October 25, 2018

**RE: Harnett County Land Use Existing Tank Application #BRES 1810-0032  
49 Wallace Street – McAdams Acres**

PERMIT NO. 6832

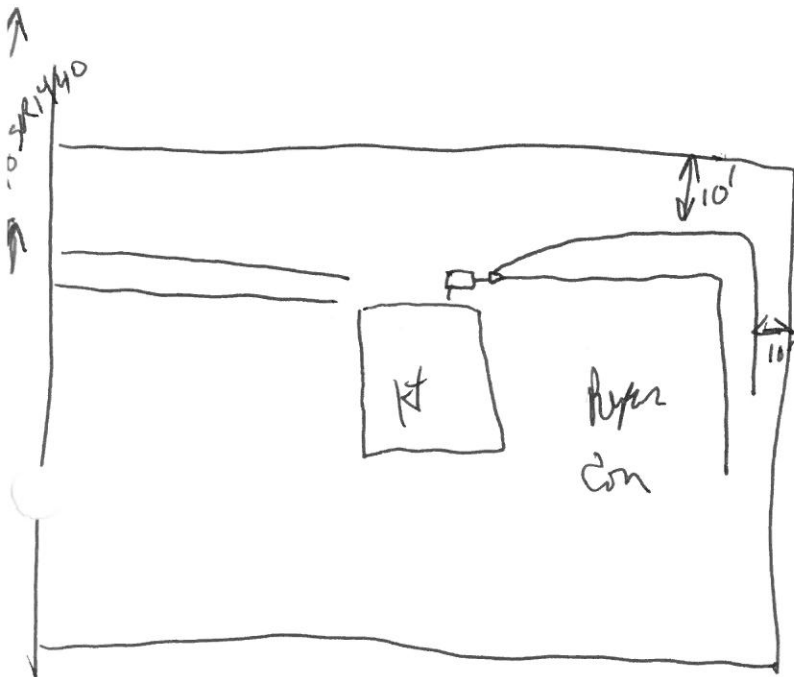
**Proposed building on existing septic drain field. Concrete sanitary tee broken with replacement required. Septic drain lines flagged onsite. Proposed building shall be located off flagged system (7ft away min.). Revise paperwork and replace tee. Applicant notified onsite. Reconfirm when ready. No revision fee.**
